Mr. R Smith,
Examining Authority
The Planning Inspectorate
Room 3D
Temple Quay House
2 The Square
Bristol
BS1 6PN

4th August 2016

**Re: Application by Wrexham Power Ltd for an Order Granting Development
Consent for the Wrexham Energy Centre**

Figure 3.1: Power Station Complex Site- Proposed Construction Access Route

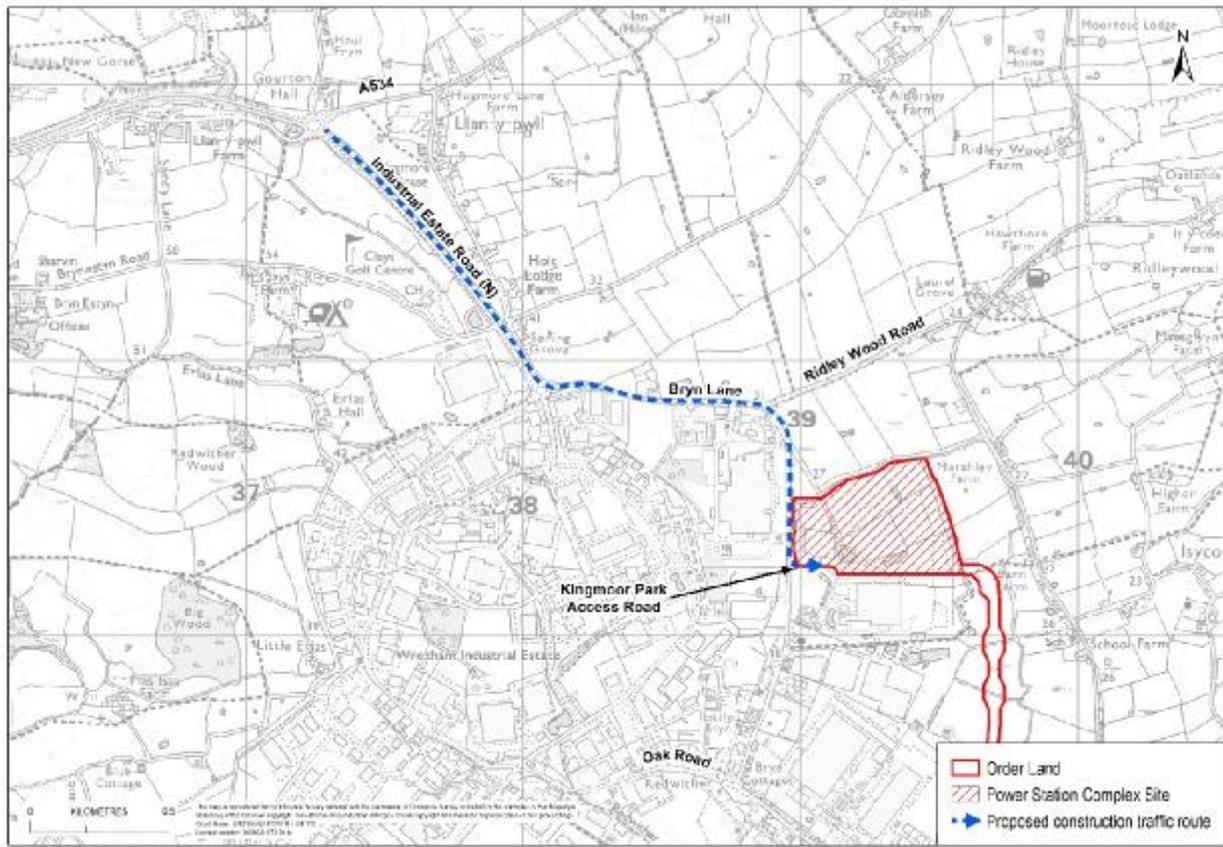
The entrance to site for all construction vehicles will be opposite Kellogg security gates and construction is expected to take 18 months. The ES shows that construction traffic will be directed along Bryn Lane in front of Kellogg's factory and we have concerns that the increased volume of traffic could impact on raw material deliveries and employees getting to the Kellogg site.

With the proposed construction traffic, Bryn Lane is anticipated to experience a 21% increase in total traffic and a 17% increase for HGVs directly outside the Kellogg site.

During concrete pouring there could be up to 300 arrivals and departures a day (for 2-3 days). This would result in a **31-40% increase in traffic** on Bryn Lane, likely over extended working hours (12-20 hours). In line with the suggestions of the construction mitigation strategy included with the application, we strongly recommend that concrete pouring occur onsite to remove the potential spike in HGV movements. This would only be accepted by us with the necessary mitigation measures put in place to control the additional dust.
